DECISION DELEGATED TO DEVELOPMENT MANAGER

Application No: H16-1234-19 **Applicant:** Burmor Projects
Proposal: Details of boundary treatment (Condition 7 of H16-0283-17)
Location: Land Off Willow Walk Spalding
Terminal Date: 10th March 2020

Details of boundary treatment (Condition 7 of H16-0283-17).

Drawing Title:
Proposed Boundary Treatments

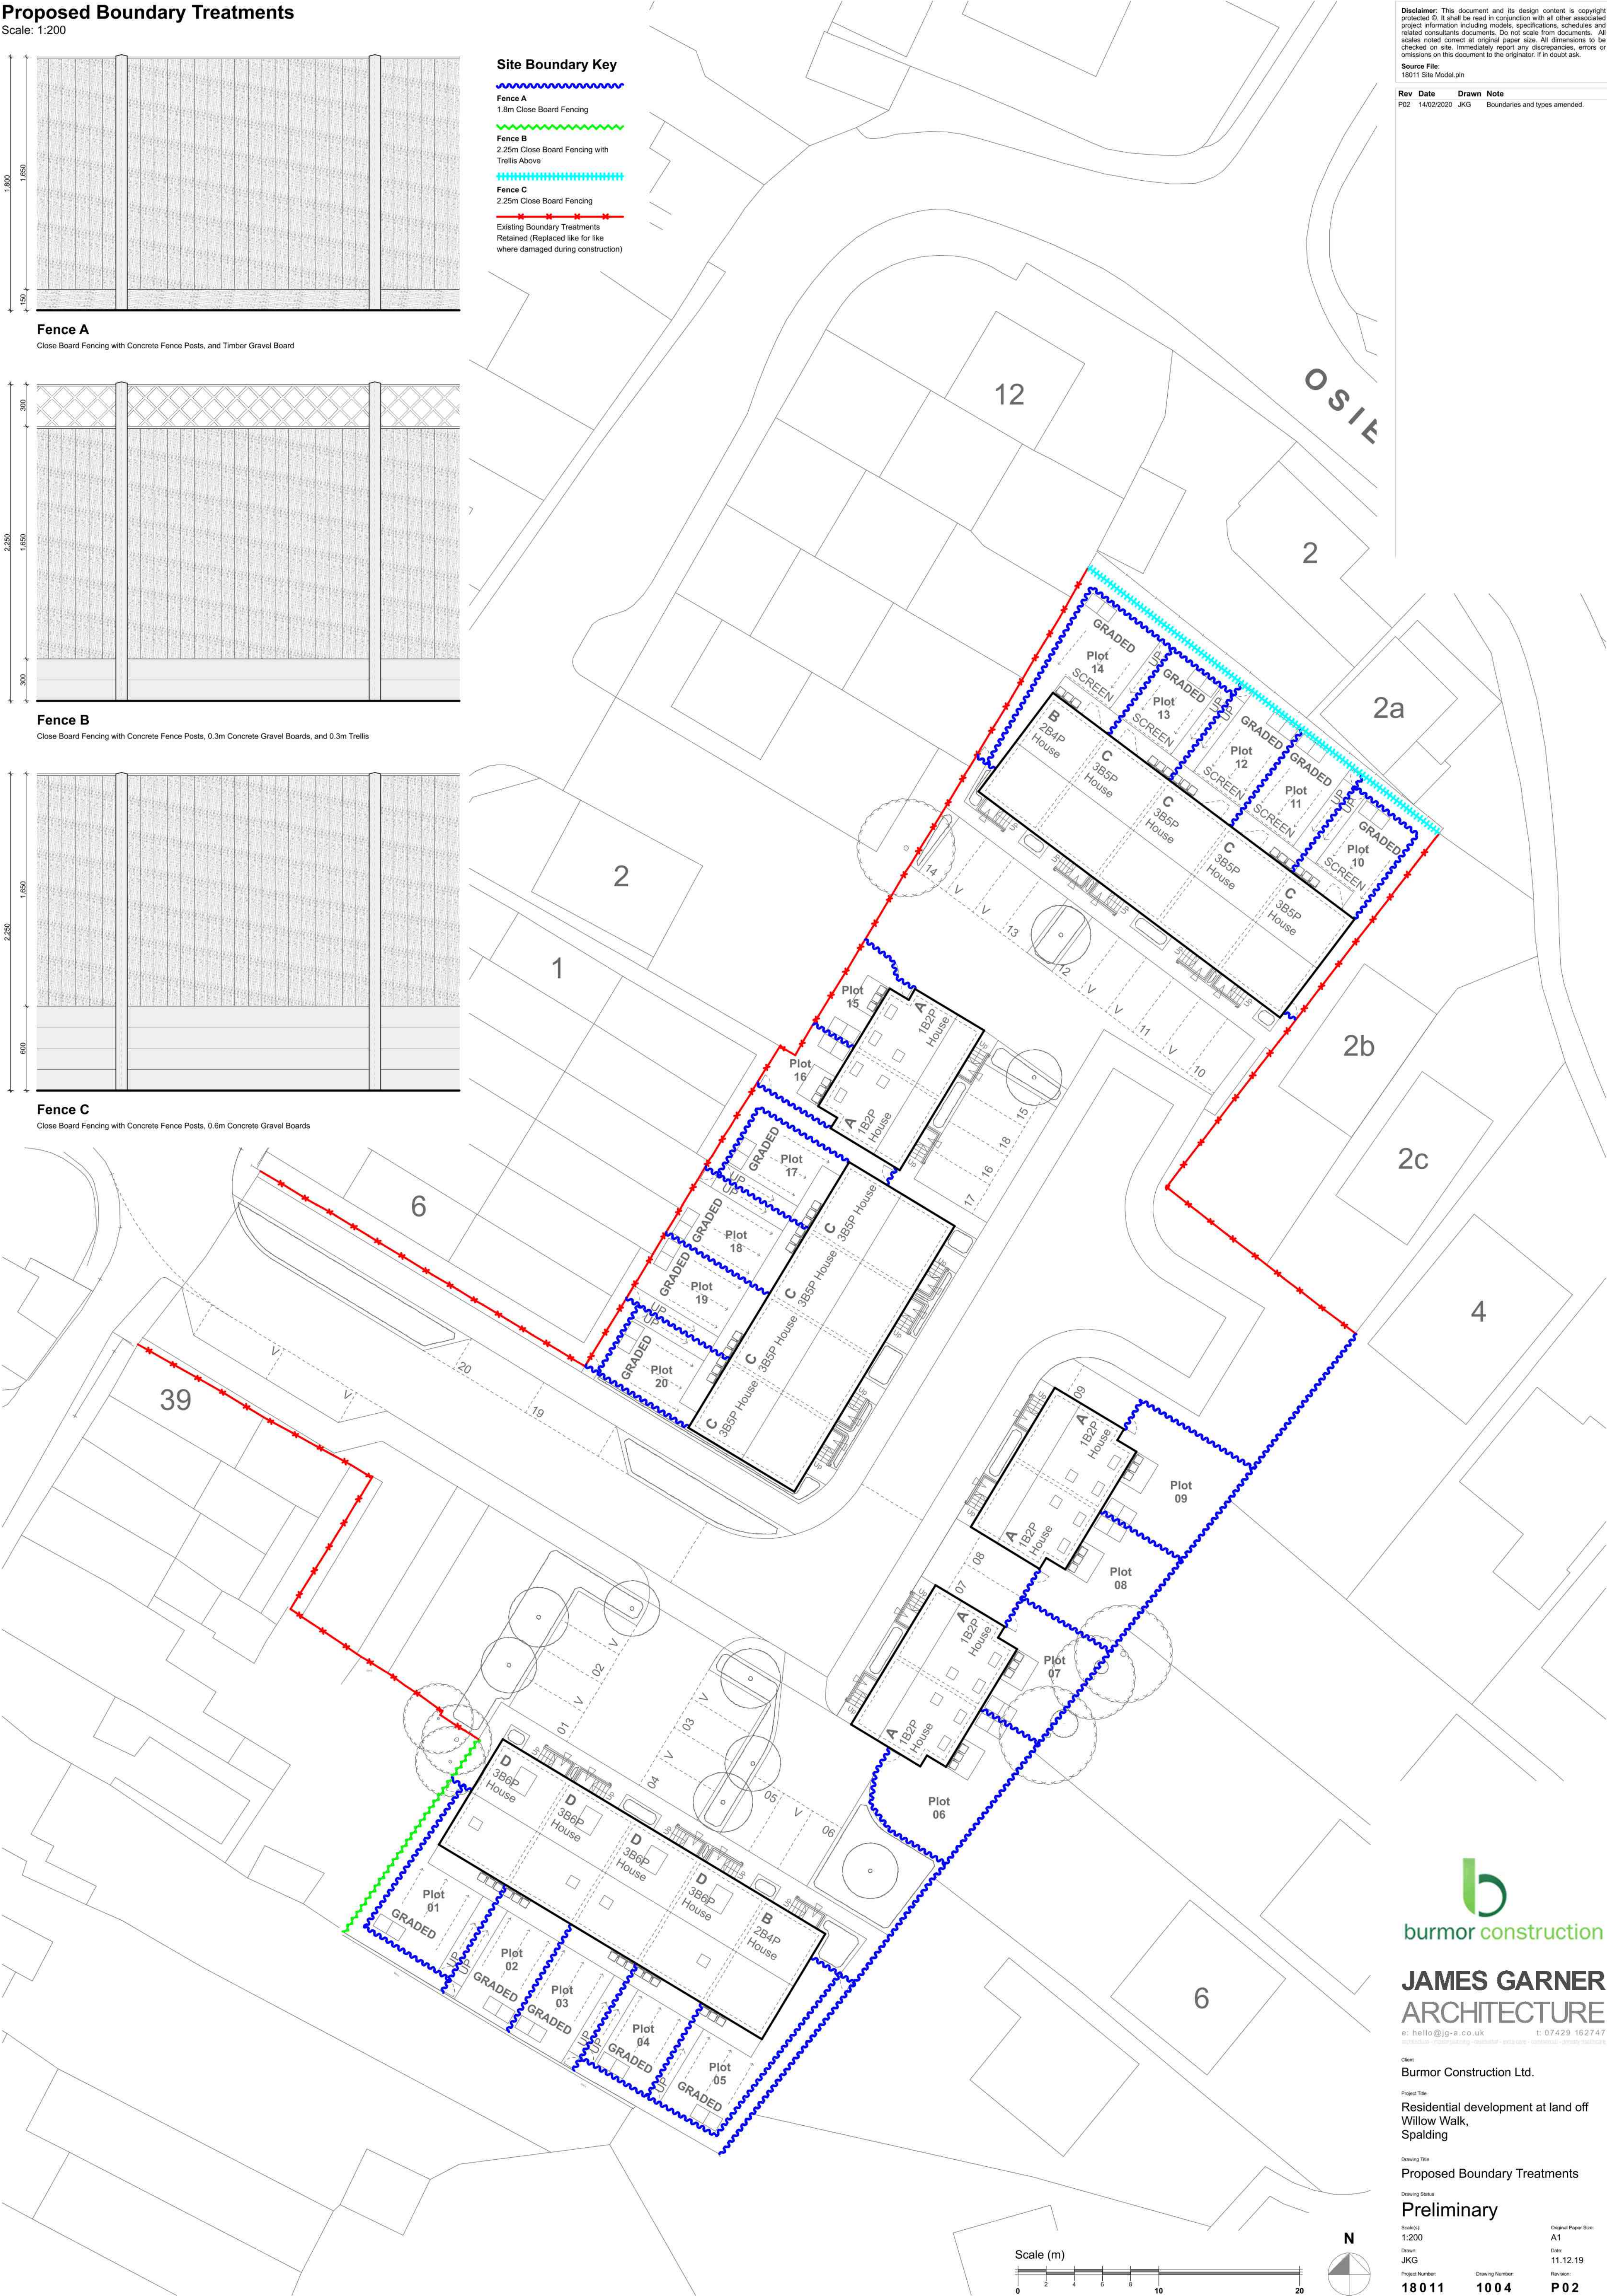
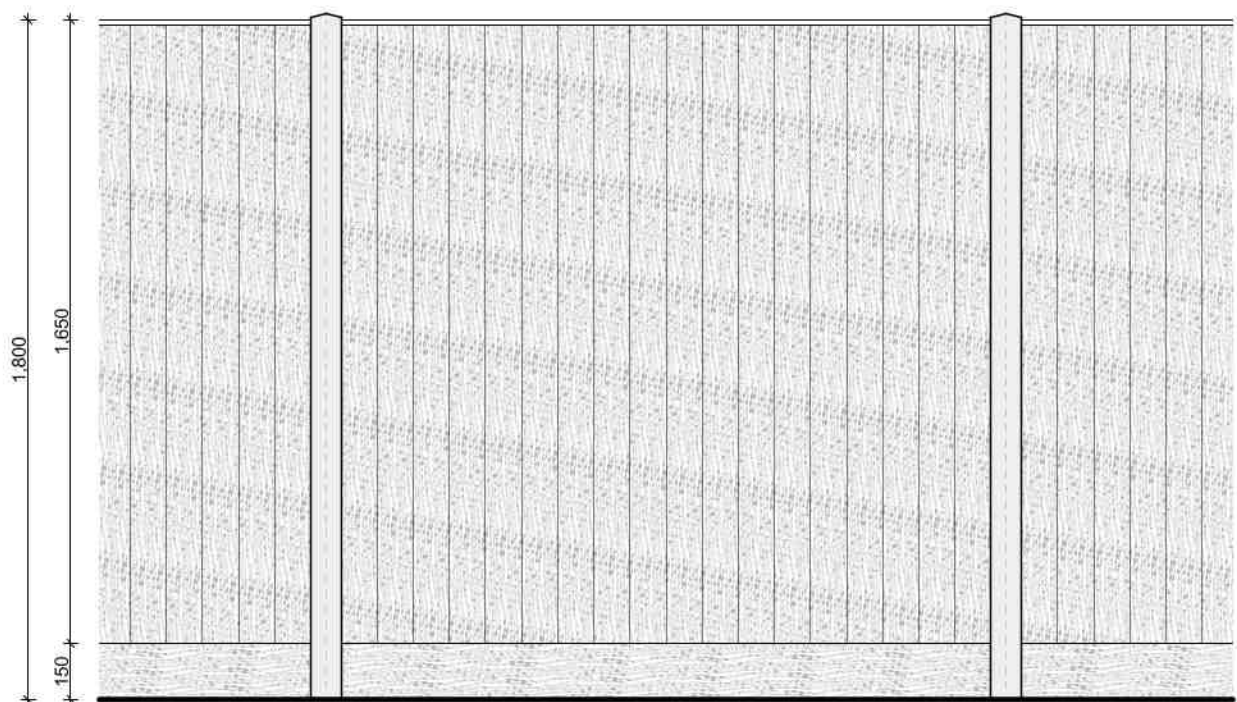
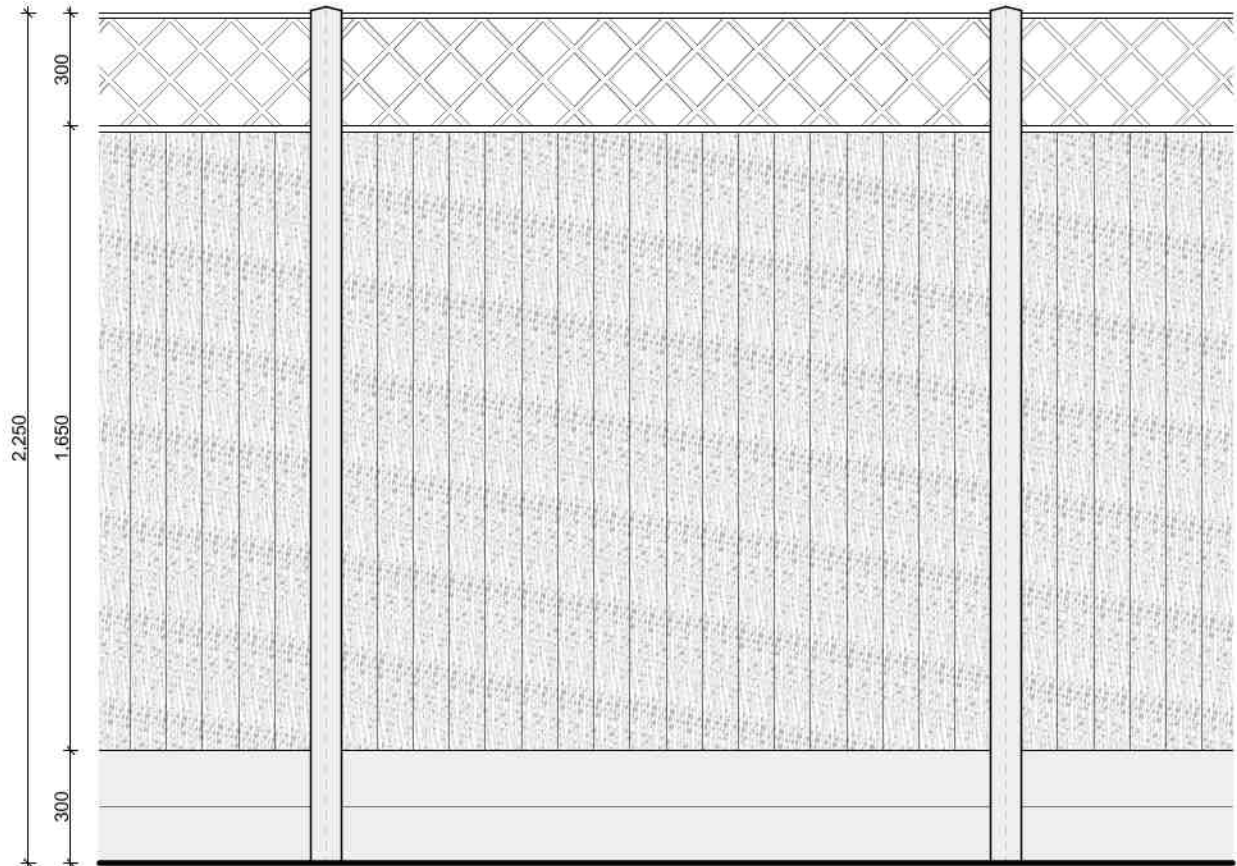
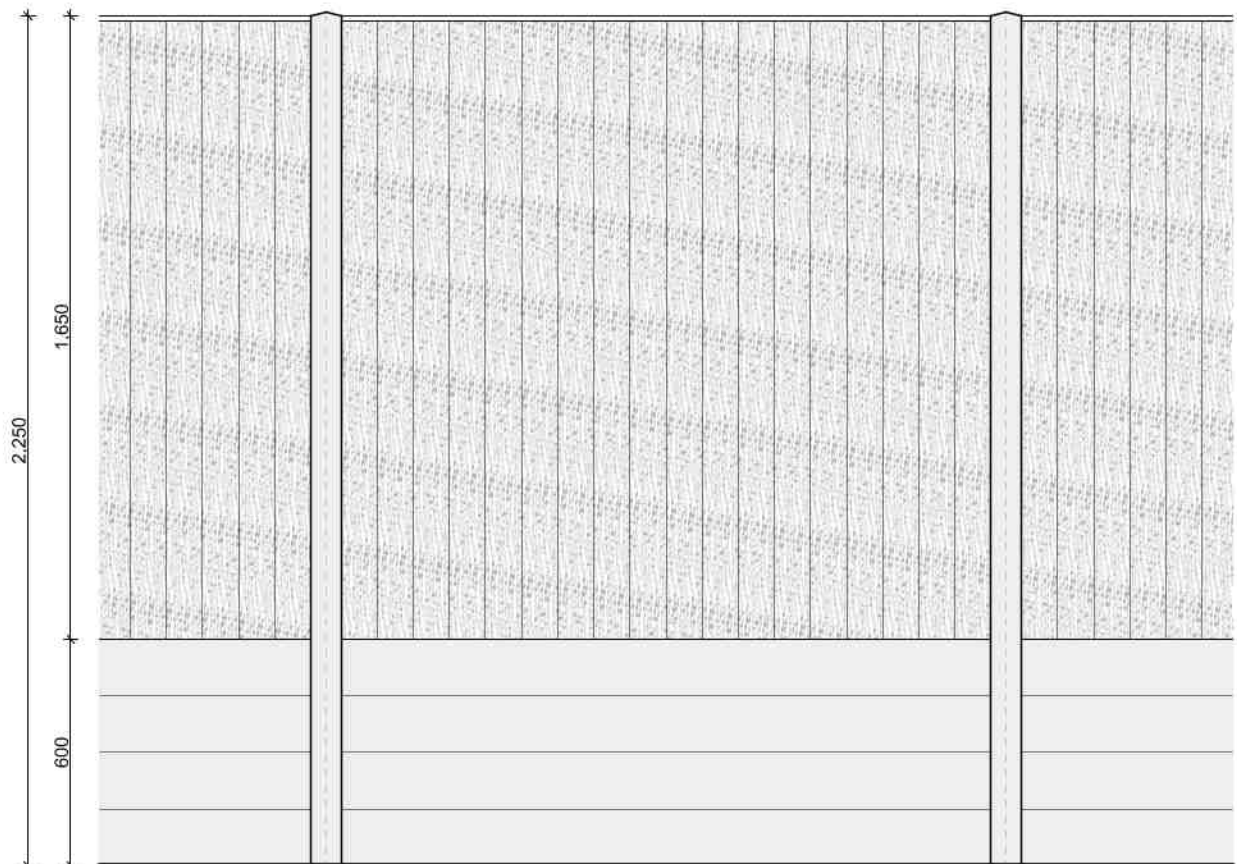
Requests that the fencing is at the greater height where it backs on to a property in Rutland Close. Also question whether the existing fencing is to be removed and replaced or use the existing fence structure. Also raise the issue of security for pets during the fencing work.

Objects to the height of the fence around the perimeter of properties in Osier Road. Some of the site with a passageway next to the garden will receive a 2.2m tall fence and some will not. Asks the council to consider for any properties that have passageways next to existing fences that the developer for security reasons should install 2.2m tall fencing and not the 1.8m fencing as shown.

The application has been amended to take in to account the requests of residents in Osier Close and Rutland Close. It is considered that the location, height and form of the fencing is acceptable and would not detrimentally impact on the privacy or amenity of adjoining residents.

Fence A - 1.8m close board fencing with gravel boards - to be used between garden plots on the development and to the western boundary of the site, adjoining properties in Rutland Close.

Fence B - 2.25m close board fencing with trellis above and gravel boards. To be used on a section of the western boundary, with properties in the High Street.

Fence C - 2.25m close board fencing with gravel boards. To be used on a section of the northern

boundary, with properties in the Osier Close.

The plans clarify that existing boundary treatments to the site are to be retained in situ and replaced with like for like if damaged during construction.
